WEST SUSSEX COUNTY COUNCIL CONSULTATION

TO:	Arun District Council FAO: Simon Davis
FROM:	WSCC - Highways Authority
DATE:	10 May 2021
LOCATION:	283-285 Chichester Road, Bognor Regis, PO21 5AH
SUBJECT:	BR/107/21/PL Replacement of semi-detached buildings with terrace of 3 No. houses. This site is in CIL Zone4 & is CIL Liable as replacement dwellings.
DATE OF SITE VISIT:	N/A
RECOMMENDATION:	Advice
S106 CONTRIBUTION TOTAL:	N/A

| SITE PLAN AS PROPOSED                                                 |         |         |                  | DRAWING NUMBER                      |                       |          |  |

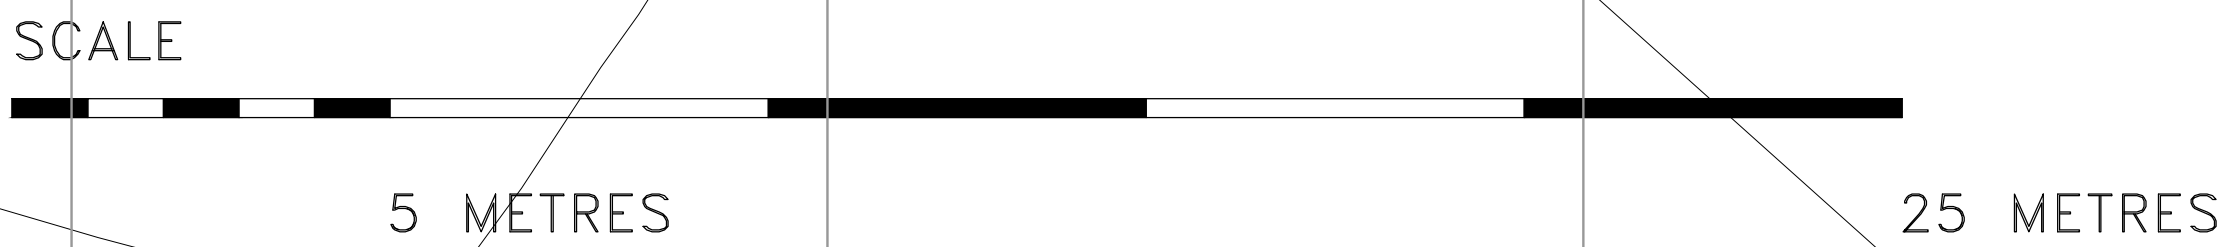
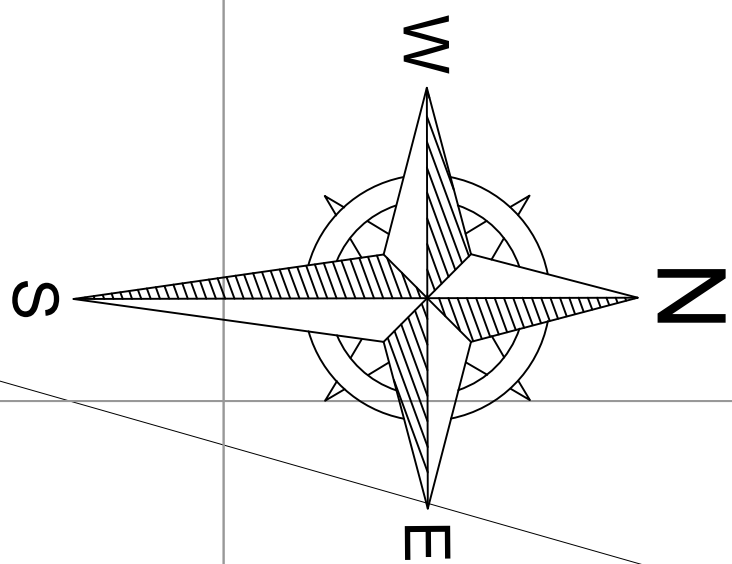
The applicant proposes to utilise the existing vehicular access on Chichester Road. From inspection of local mapping, there are no apparent visibility issues with the existing point of access onto the maintained highway. The LHA does not anticipate that the proposed development would give rise to a significant material intensification of movements to or from the site.

The applicant proposes six car parking spaces for this development. Under Arun Parking Standards, the LHA would expect a parking provision of at least three car parking spaces for a development of this size in this location. Therefore, the LHA considers the proposed parking provision to be sufficient. On-site turning appears achievable, allowing cars to exit the site onto Chichester Road in a forward gear.

Regarding cycle parking, the applicant has demonstrated secure and covered cycle stores to the rear of each plot, in accordance with Arun Parking Standards. The inclusion of cycle parking provision helps promote the use of sustainable transport methods.

No part of the development shall be first occupied until the car parking has been constructed in accordance with the approved site plan. These spaces shall thereafter be retained at all times for their designated purpose.

No part of the development shall be first occupied until covered and secure cycle parking spaces have been provided in accordance with plans and details to be submitted to and approved by the Local Planning Authority.

No part of the development shall be first occupied until the electric vehicle charging space(s) have been provided in accordance with plans and details to be submitted to and approved by the Local Planning Authority.
